Subject: Response to Submissions – Kings Park Metal Recovery and Recycling Facility Expansion (SSD-10396) (Blacktown)

Environment, Energy and Science Group (EES) has reviewed the relevant documents and provides the following comments regarding flood risk management.

Flood Risk Management

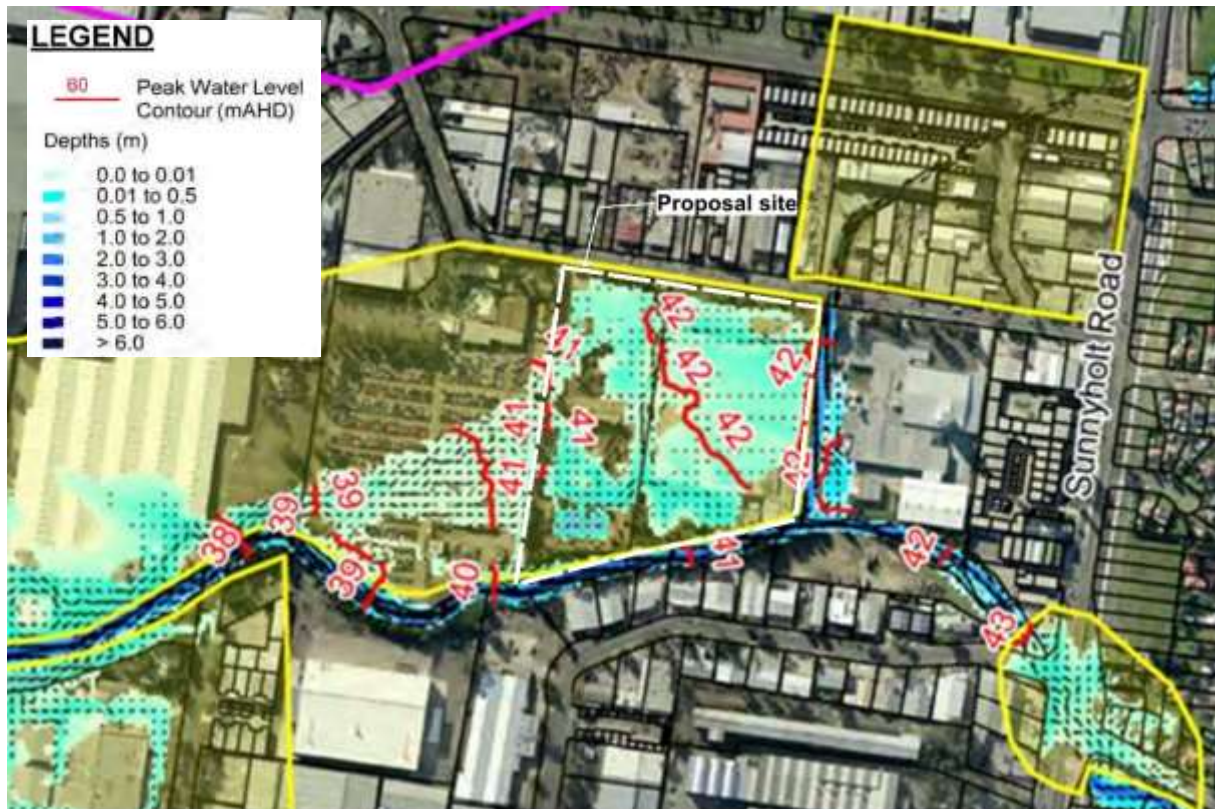
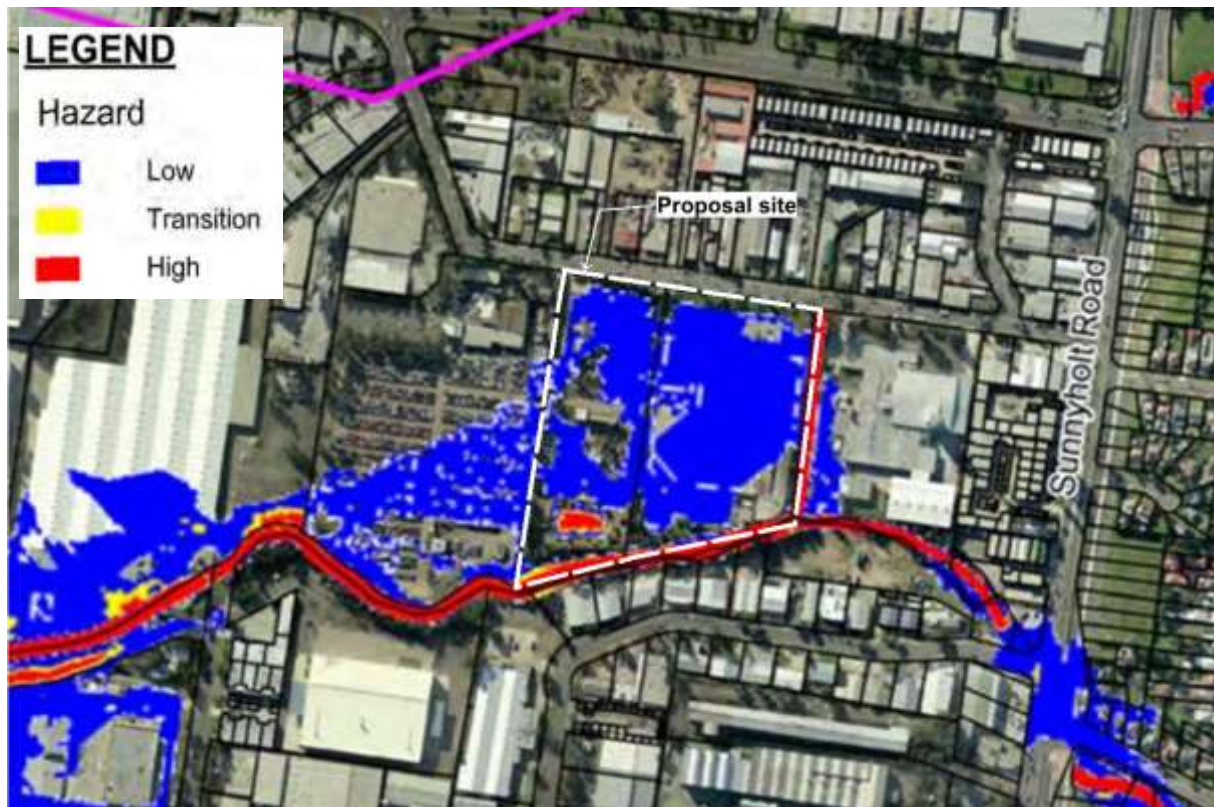
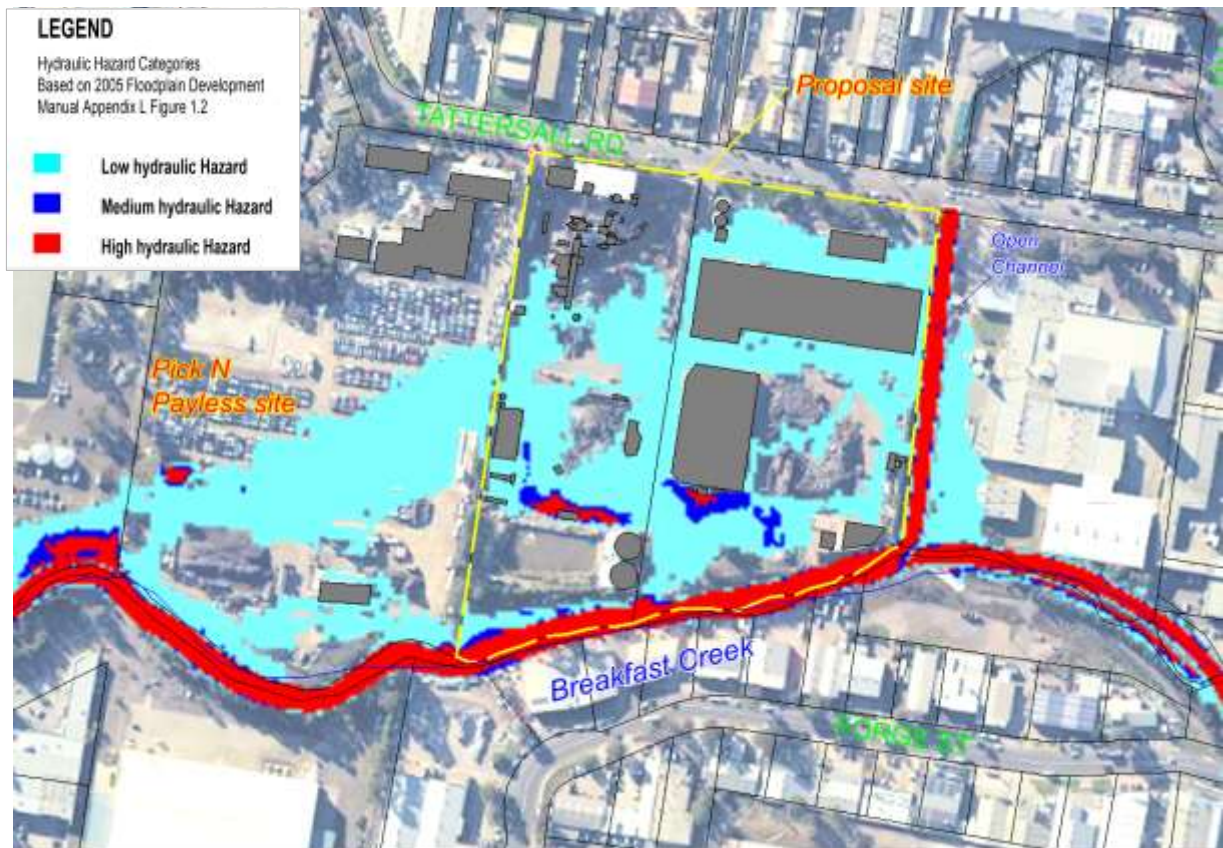
1. EES highlights that, the flood impact and risk assessment should adequately outline existing flood behaviour for the full range of flooding up to the Probable Maximum Flood (PMF). ARCADIS's assessment is limited to the 1% AEP.

The RtS response has not addressed the above comment. The flood assessment should provide a sound understanding of the flood behaviour for the full range of flooding up to and including the PMF. Addressing the full range of flooding is prudent to guide decisions on this proposal.

2. The Eastern Creek Hydraulic Assessment (CSS, 2014) shows the site is largely inundated in the PMF event and classified high hazard. Accordingly, consideration should be given to the emergency management of the site during rarer events up to the PMF to ensure the safety of the workers and users of the site.
